# Planning Consultation Request

Application No.	2019/93920
Proposed Development:	Erection of 12 apartments
Location:	land adj, 63, Wakefield Road, Moldgreen, Huddersfield, HD5 9AB
OS Map Reference	SE 415249416357
Applicant/Agent:	Acumen Designers & Architects Ltd
Class:	Small Major Developments

**Consultation Response from KC,  
 Conservation and Design**
**2019/93920 land adj, 63, Wakefield Road, Moldgreen, Huddersfield, HD5 9AB**
**Erection of 12 apartments**
**Date**
**Responded:16/01/2020**
**Responding Officer: NH**
**Responding Ref:**

FRONT ELEVATION

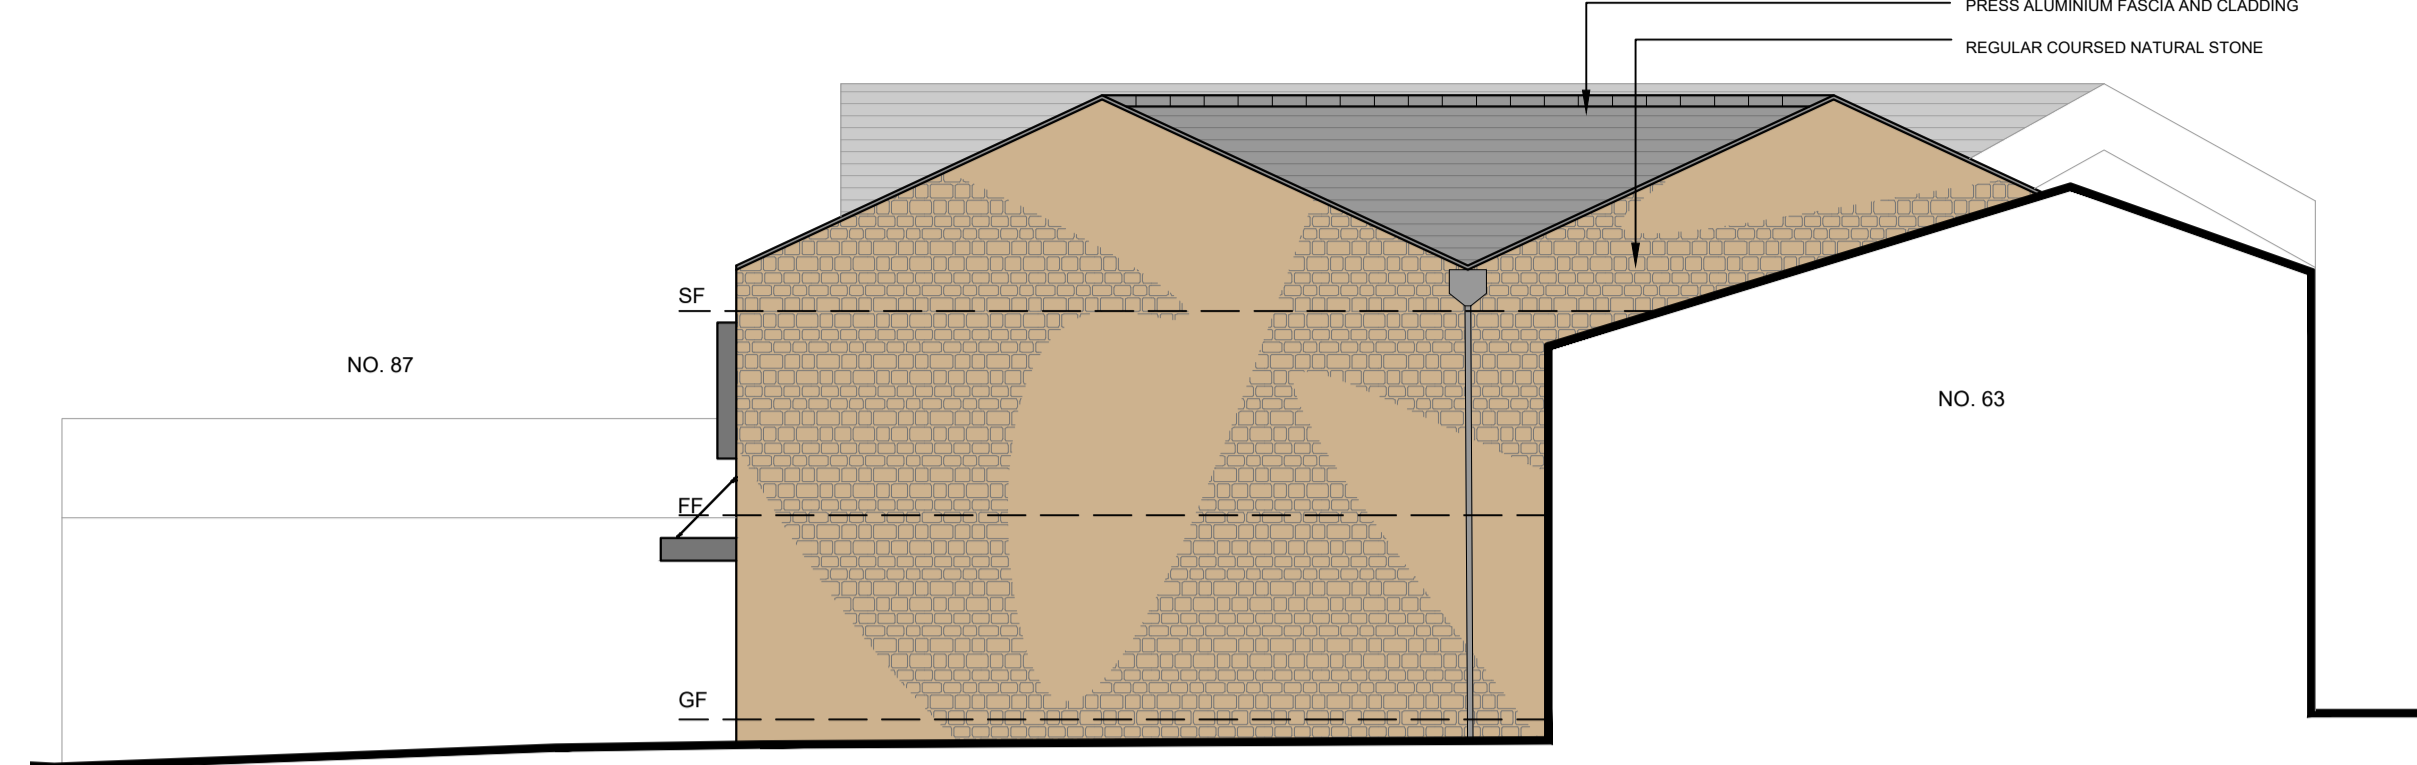
The proposal is for a three storey building, constructed in stone, with four flats per floor. The building is as previously mentioned of stone construction with a flat roof. The building is entered via a central door on the frontage, with a row of four windows with stone surrounds on the ground floor and a two rows of four windows that are vertical linked across the floors by surrounds; it is unclear whether these surrounds project beyond the elevational plane to form boxes so I have assumed this is not the case. The Heritage Statement states:-

There is no doubting that this is the case, the building does not reflect the adjacent listed buildings in terms of the scale, the flat roof and the detailing. This is an issue as in my mind, this is too far a change. In effect it is a storey too high in my opinion and I am not convinced by the flat roof treatment that terminates at the elevation higher than the ridge line of the adjacent buildings. There is no consistent eaves line across from 63 to 87 and as such with the height of the building there will be a significant step up from both sides. As mentioned previously one of the reasons for listing relates to the “bookend” approach of 89 Wakefield Road and 2 Silver Street, with the step being between 87 and 89; this would introduce a feature that is not consistent with the ‘run’ of buildings. Equally there are no flat roofs in this area so again this is not in context with the surroundings. There are consistent eaves details across the row as well as a sill band that runs below the first floor windows. There are no eaves treatments and the sill band actually sits below the sill band of the adjacent properties. This therefore interrupts the eye and does not follow the degree of consistency that is afforded now.

I am not against modern interventions in historic streetscapes but where this occurs there should be more relationships with the existing and details passed across to help mitigate the change. I am not convinced that this is the case here and as such I would recommend that the design is altered, both in terms of scale and detailing. I would suggest that in its current form it is contrary to Section 66 of the Act in so far as the application fails to preserve or enhance the setting of the adjacent listed building, fails policy LP35 of the Kirklees Local Plan for the same reason and fails to comply with Paragraph 196.
